Modification 1 - Amendments to apartment layouts, roof structure, PMF design level and anti-graffiti conditions (SSD-8019-Mod-1)

Request for Additional Information

SITE ELEVATIONS

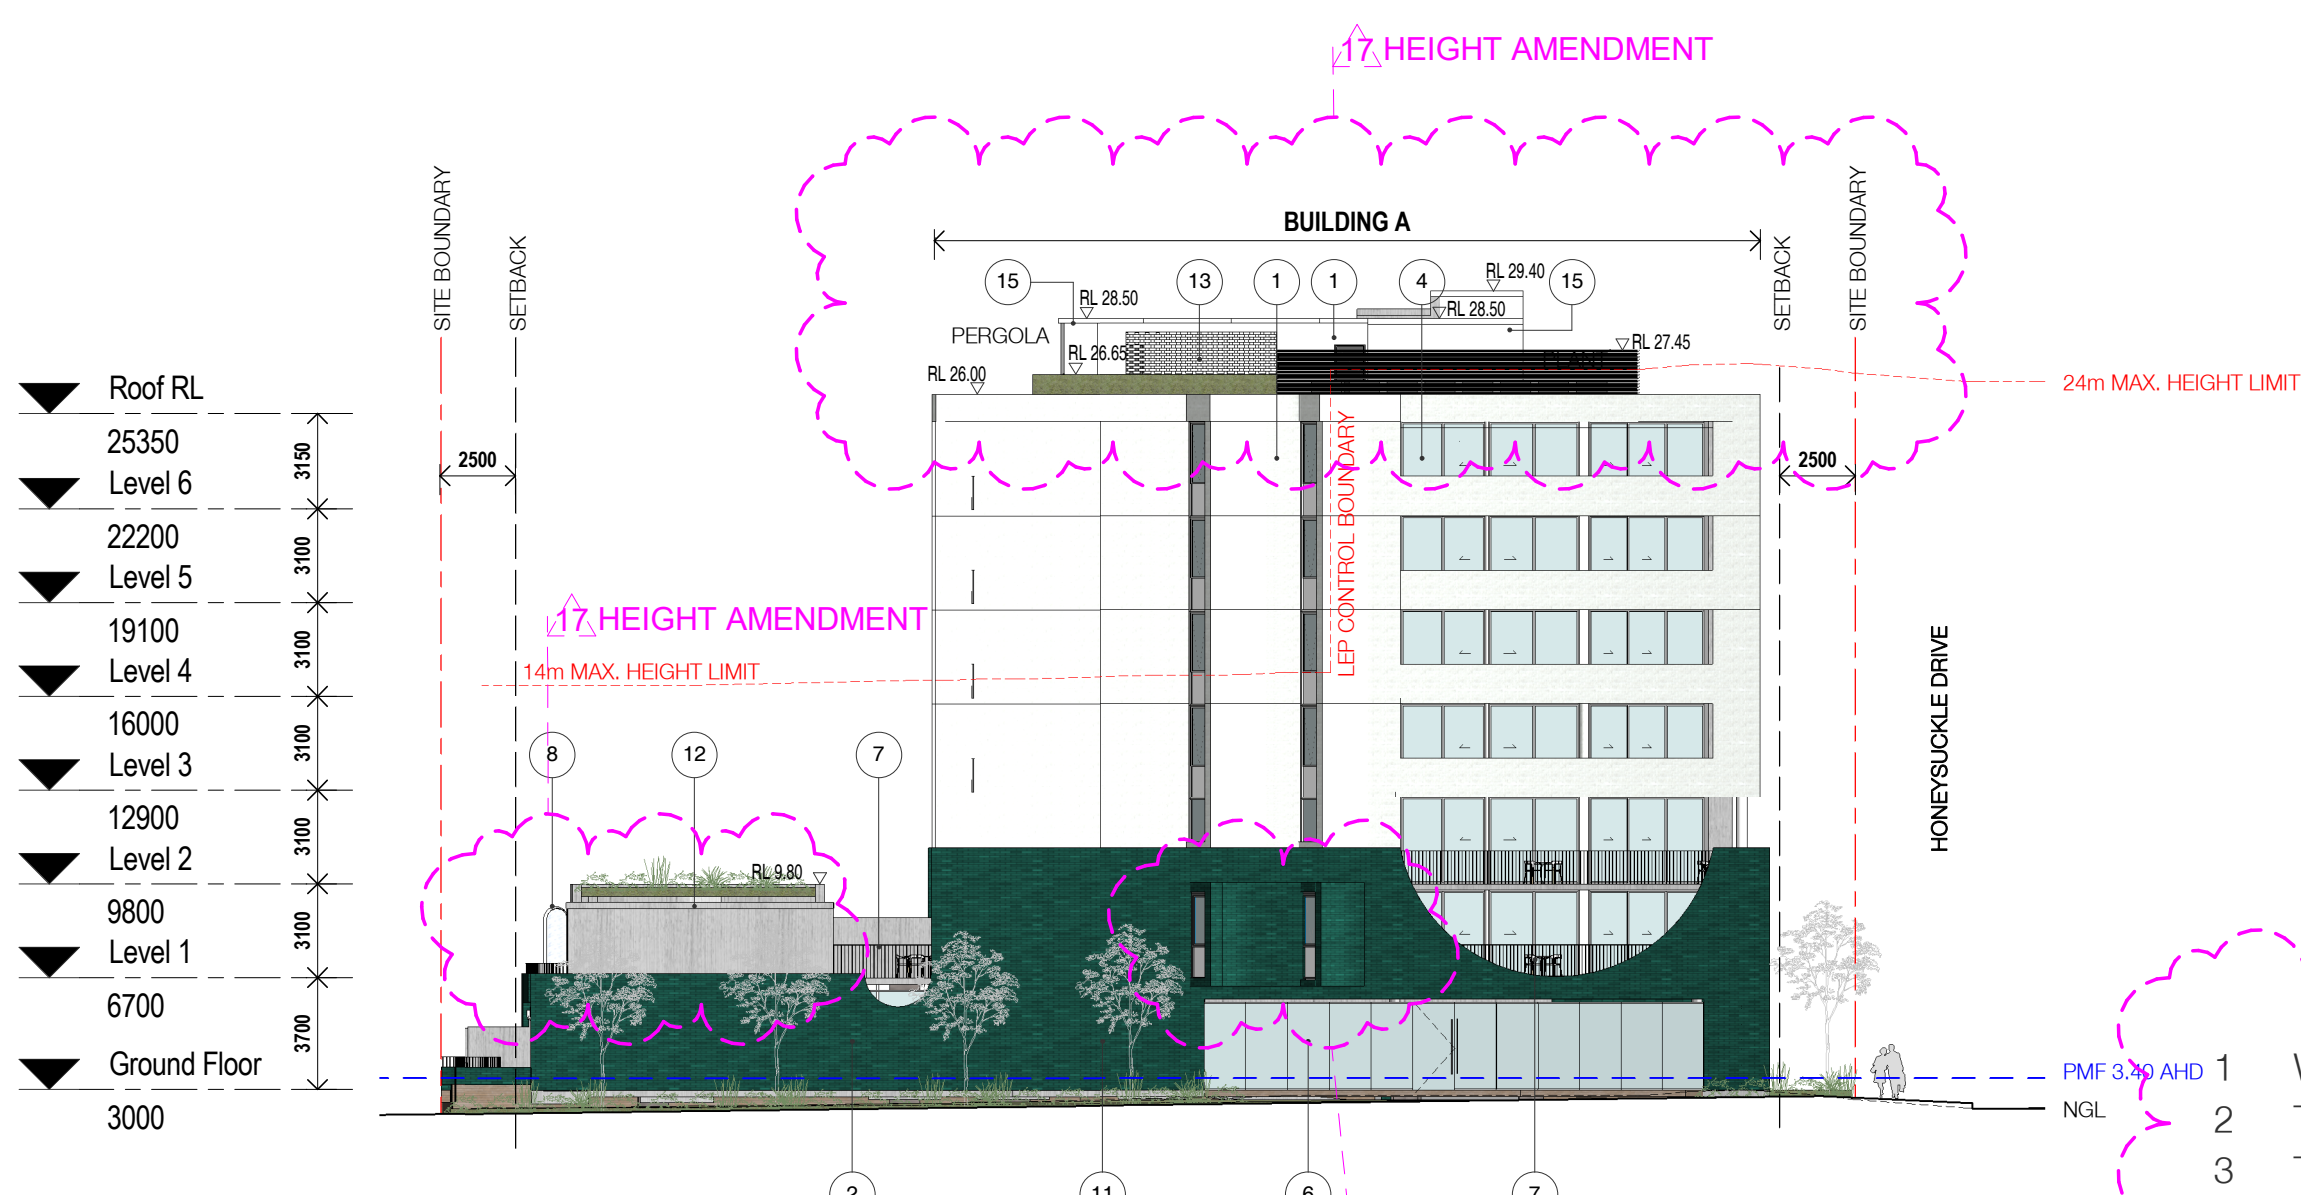
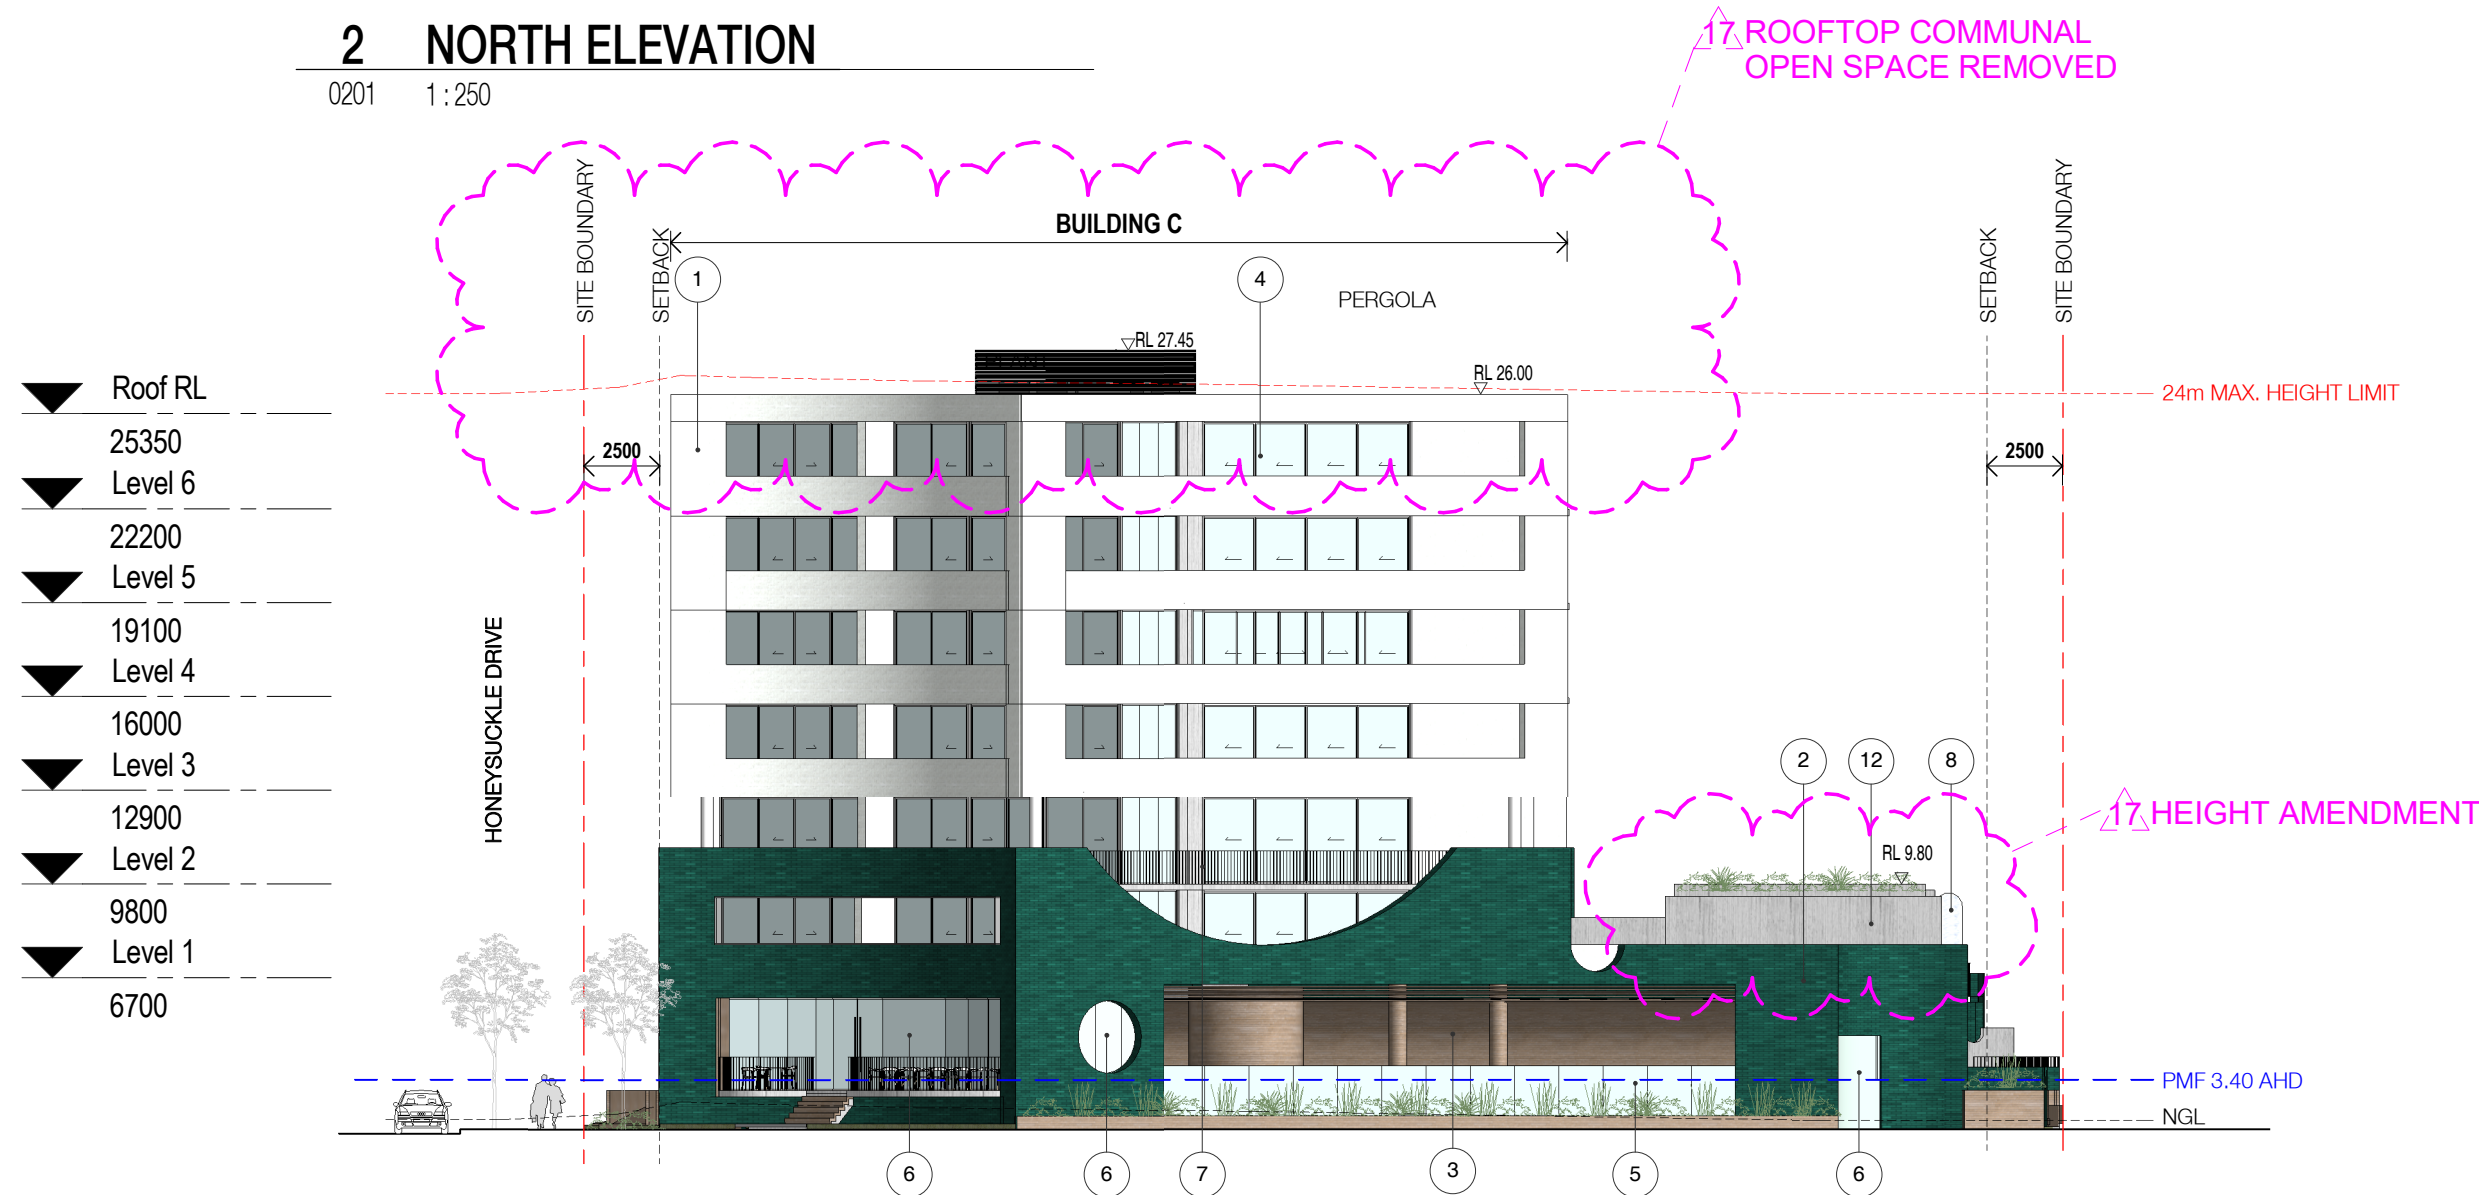
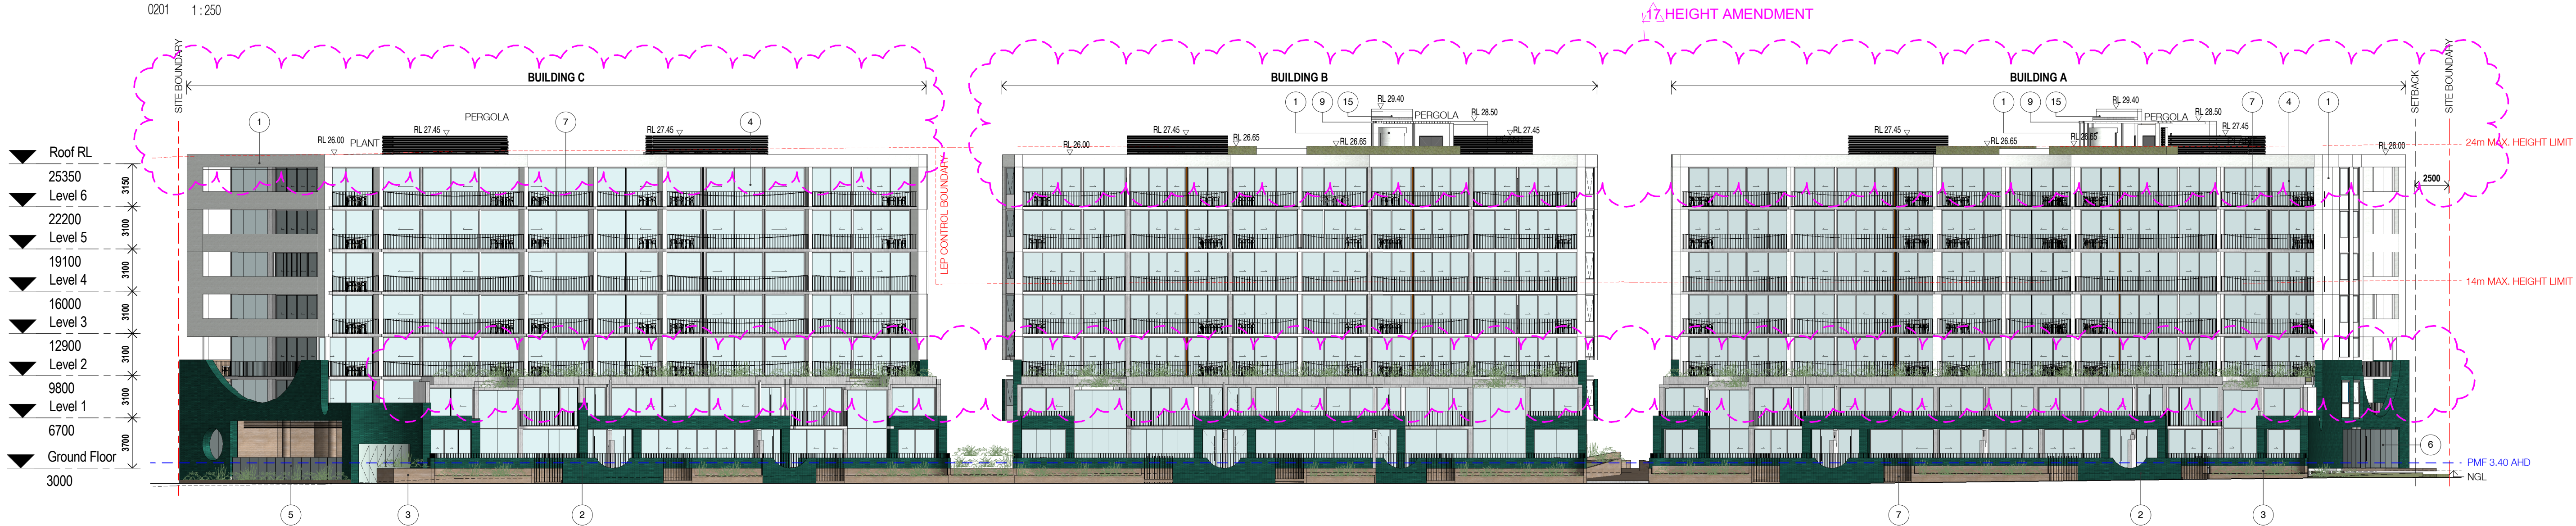
- provide reasoning for the change in decorative brick work from terracotta to white on the proposed external façade. The Department considers that the approved terracotta brick work assists in breaking up the horizontal mass of the buildings and as such, should be retained.
- clarify whether the changes to the outdoor balcony on the ground floor commercial tenancy allow the enclosure of that area and therefore result in additional floor area.
